Subject: M/94/17/PL 72 Ancton Way Planning Application

M/94/17/PL - 72 Ancton Way, Elmer, Middleton on Sea. PO22 6JP

We write in respect of the planning application to demolish and rebuild 72 Ancton Way, Elmer.

SCALE:	As shown @ A3	
DATE:	July 2017	
DRAWN:	ASW	
CHECKED BY:	CW	
DRAWING NO:		
N265	PL02	*

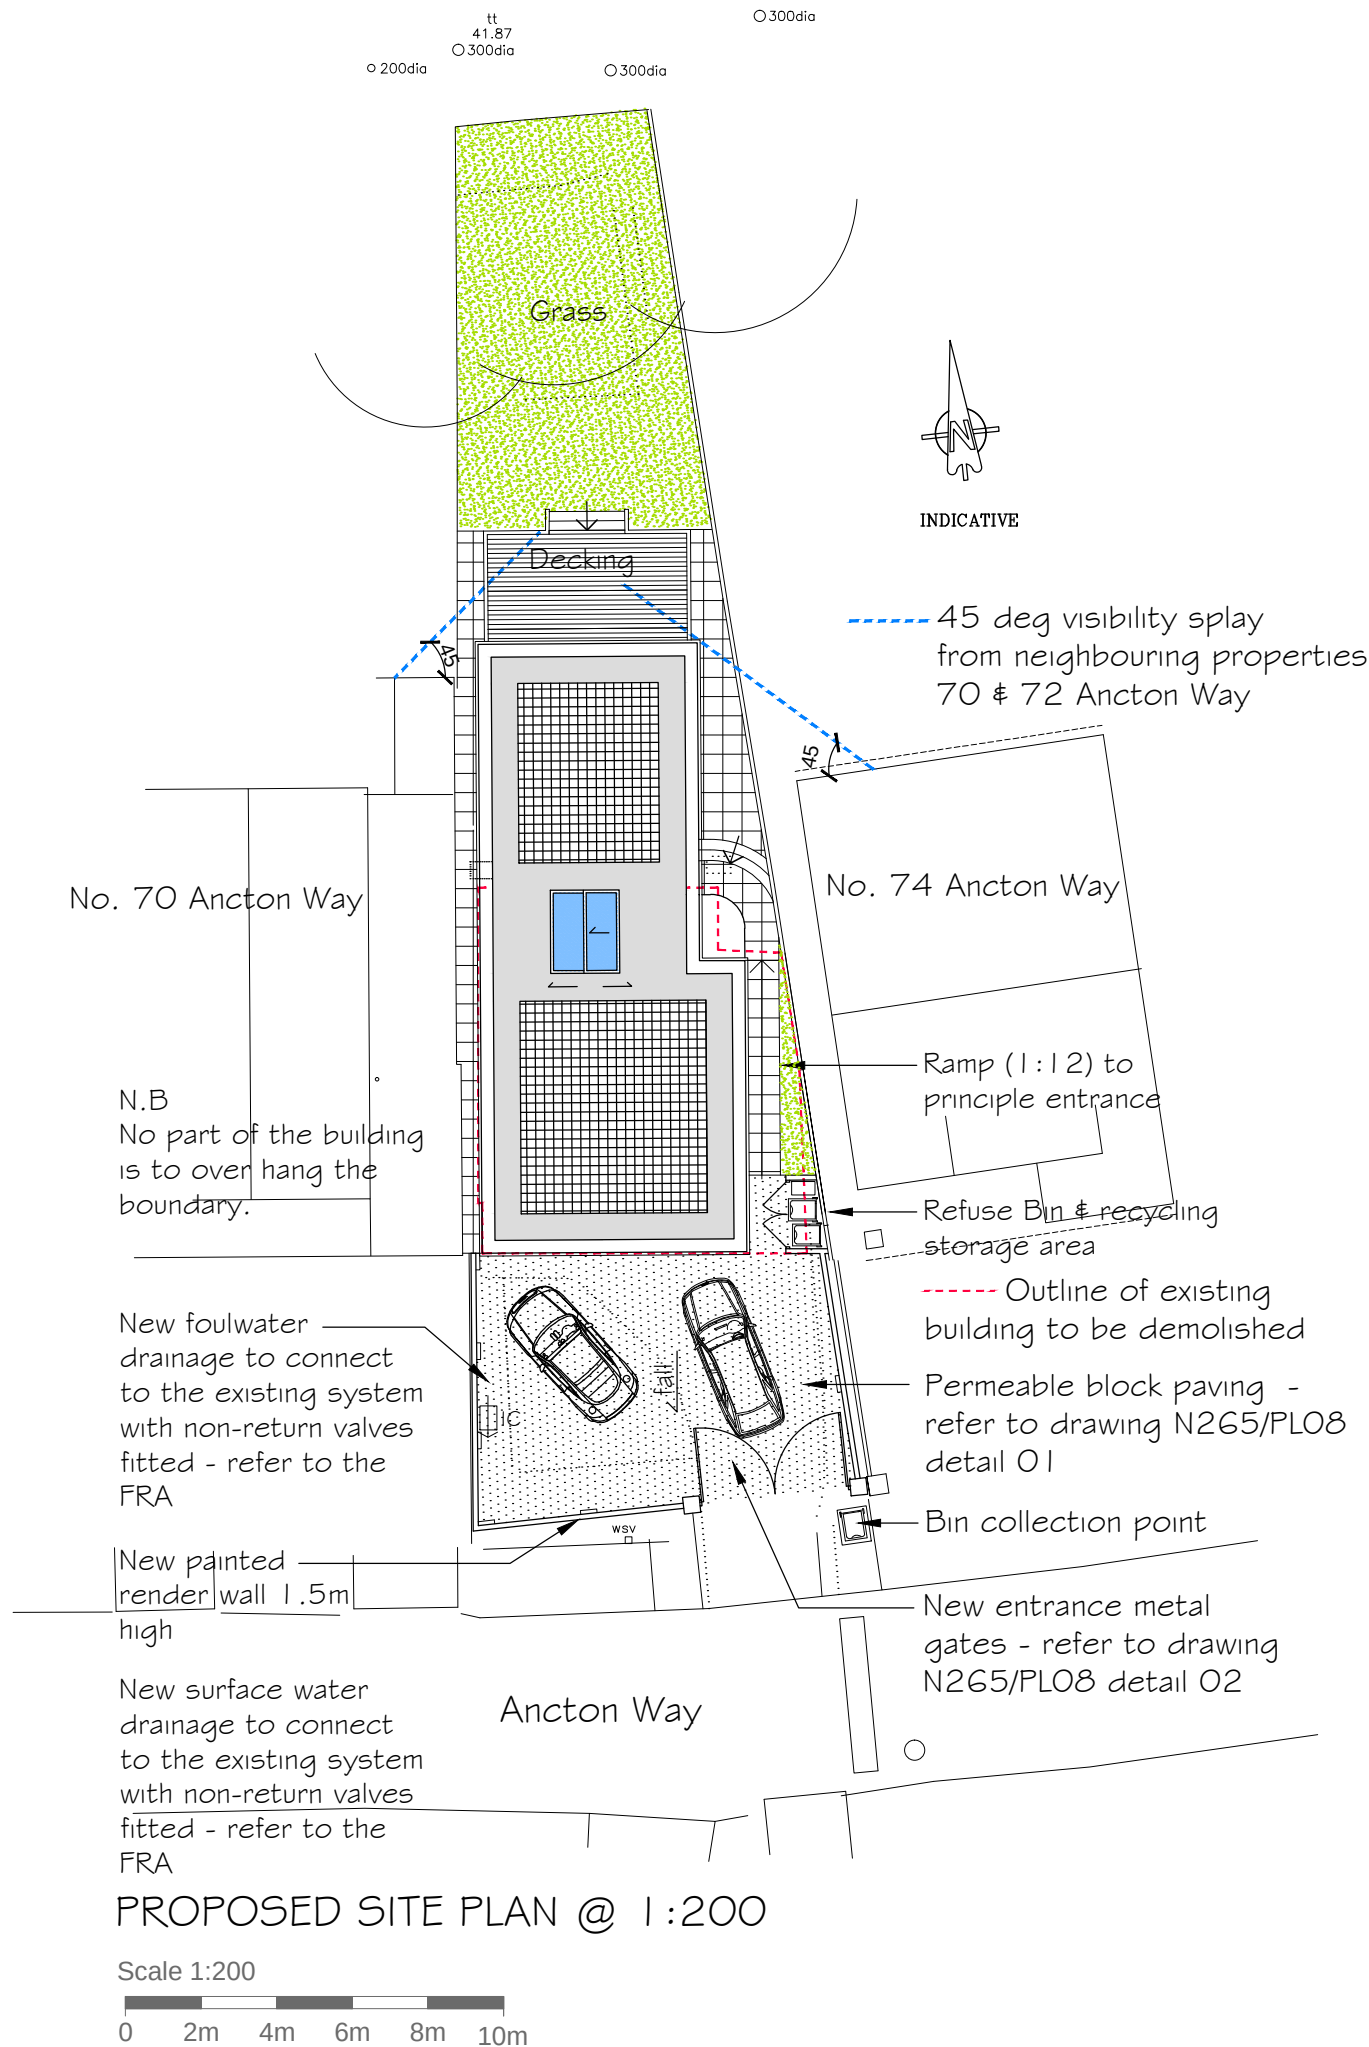
In item 12 of the application the statement is that surface water will be disposed of using the "existing water course". Also plan N265 PL02 states "New surface water drainage to connect to the existing system with non-return valves fitted - refer to the FRA". Paragraph 3.9. of the FRA states "Surface water drainage: the development's surface water will be routed into the sea, as per the existing site's surface water."

Whilst Paul Cann ADC has provided soak away and/or SUD specifications for the disposal of surface water, for clarity we need to state that connection to an existing surface water drain is not acceptable. The only one in the area being the surface water drain installed on Elmer Sands Limited land, to provide a course for water from the road surface, eastwards to the Ryebank Rife and on to the sea. This surface water drain does not have the capacity to carry water from Ancton Way properties or the wider area. Therefore there is no agreement to connect to this surface water drain owned by Elmer Sands Limited.
